**Project Application SSD 13_5855: Banksmeadow Waste Transfer Terminal – 14
Beauchamp Road, Banksmeadow**

We refer to the Environmental Impact Statement currently on exhibition for the above project. A review of the project documents has been undertaken in relation to potential impacts or interfaces with Ausgrid's electricity infrastructure.

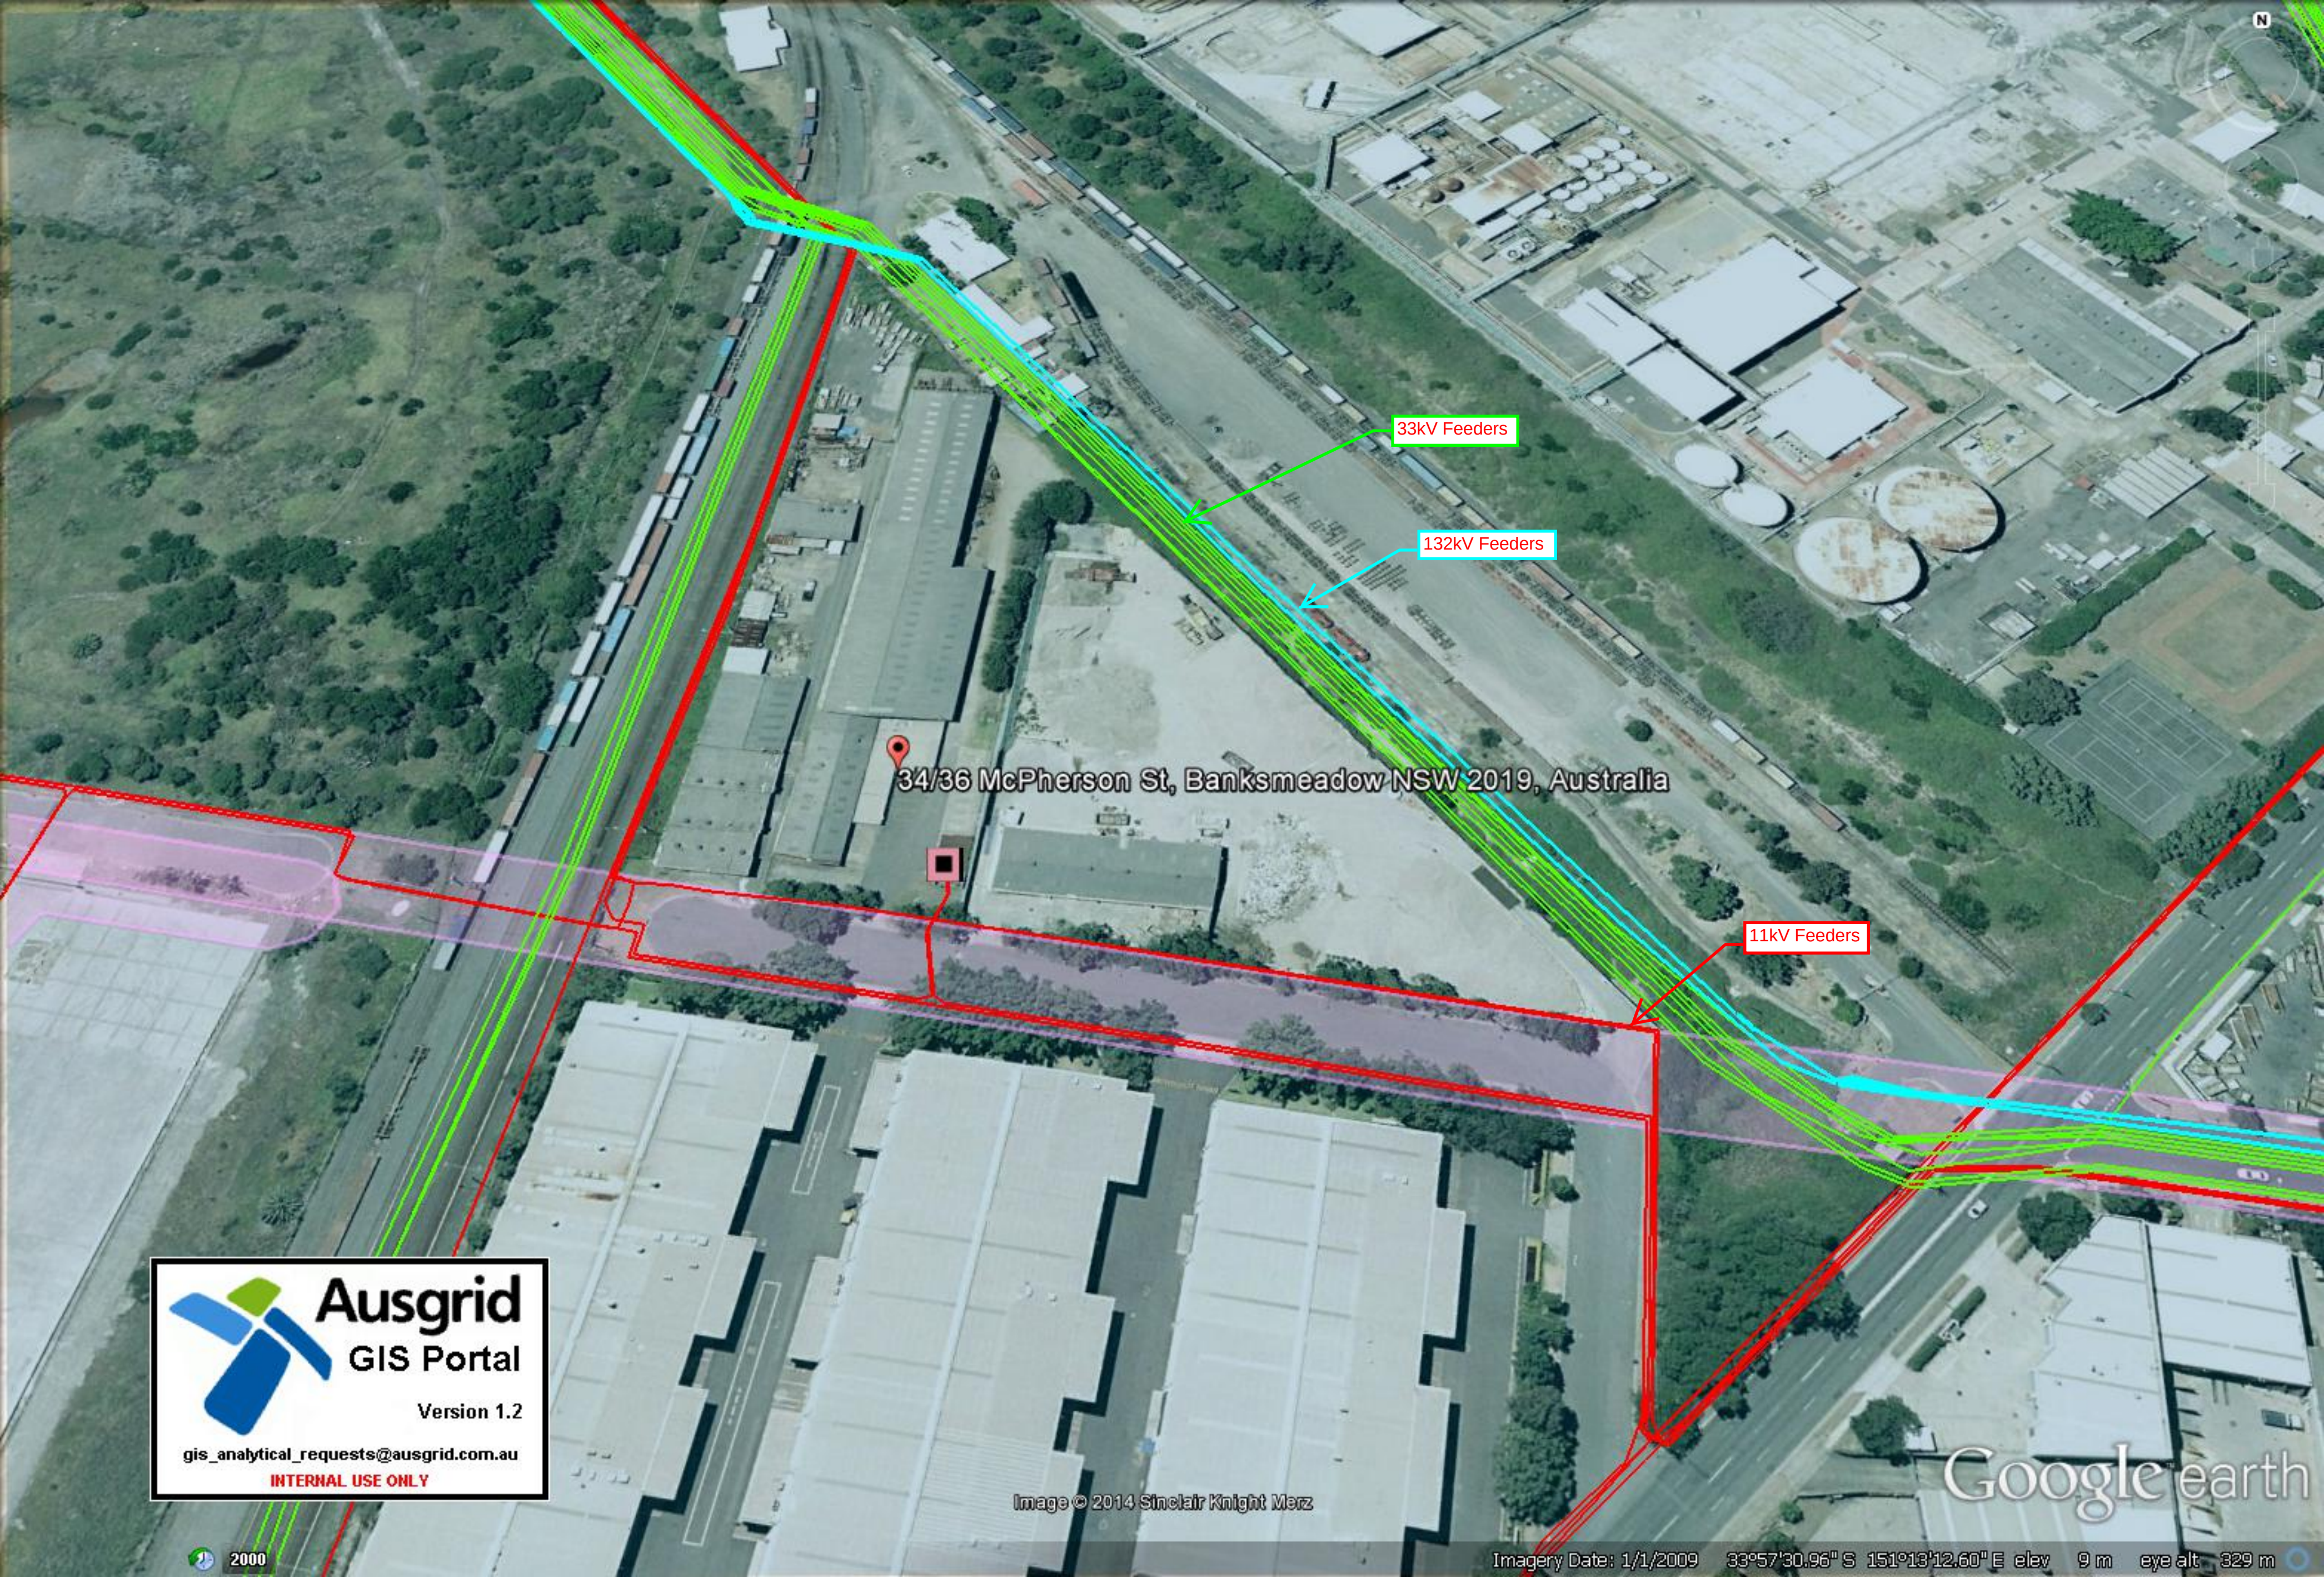
Ausgrid is concerned with the limited amount of consultation it has received in regards to this proposal. There are a substantial amount of critical electricity assets within the proposed development site including nine important high voltage electricity cables (7x33,000V and 2x132,000V) and twelve joint bays. There are also additional electrical assets on the exterior of the proposed land which could potentially be impacted by the proposed works.

To demonstrate the large volume of electrical assets within the proposed development area we attach a Google earth plan overlayed with details of Ausgrid's electricity feeders for your consideration.

- i. must, unless otherwise agreed in writing with Ausgrid, enter into an Agreement to ensure Ausgrid's capacity to design, construct and operate existing and future infrastructure is not impeded, including works affecting easements, conduit corridors, cable routes or works that require the removal or relocation of existing infrastructure;
- ii. must confirm with Ausgrid the location and status (e.g. live, de-energised, isolated, abandoned) of existing Ausgrid infrastructure;
- iii. must liaise with Ausgrid in relation to any aspects of the development that may impact or potentially impact Ausgrid's infrastructure or ability to safely operate and maintain its infrastructure. This includes but is not limited to minimum clearances,

maintaining access, impacts on cable ratings, structural integrity and ventilation, as well as effects of vibration, excavation and construction works;

- iv. must liaise with Ausgrid to determine the relocation of any existing Ausgrid infrastructure to the satisfaction of Ausgrid in its absolute discretion;
- v. must liaise with Ausgrid to agree appropriate work methodologies in the vicinity of Ausgrid's infrastructure; and
- vi. must comply with relevant network and safety standards as well as the terms of the Agreement.
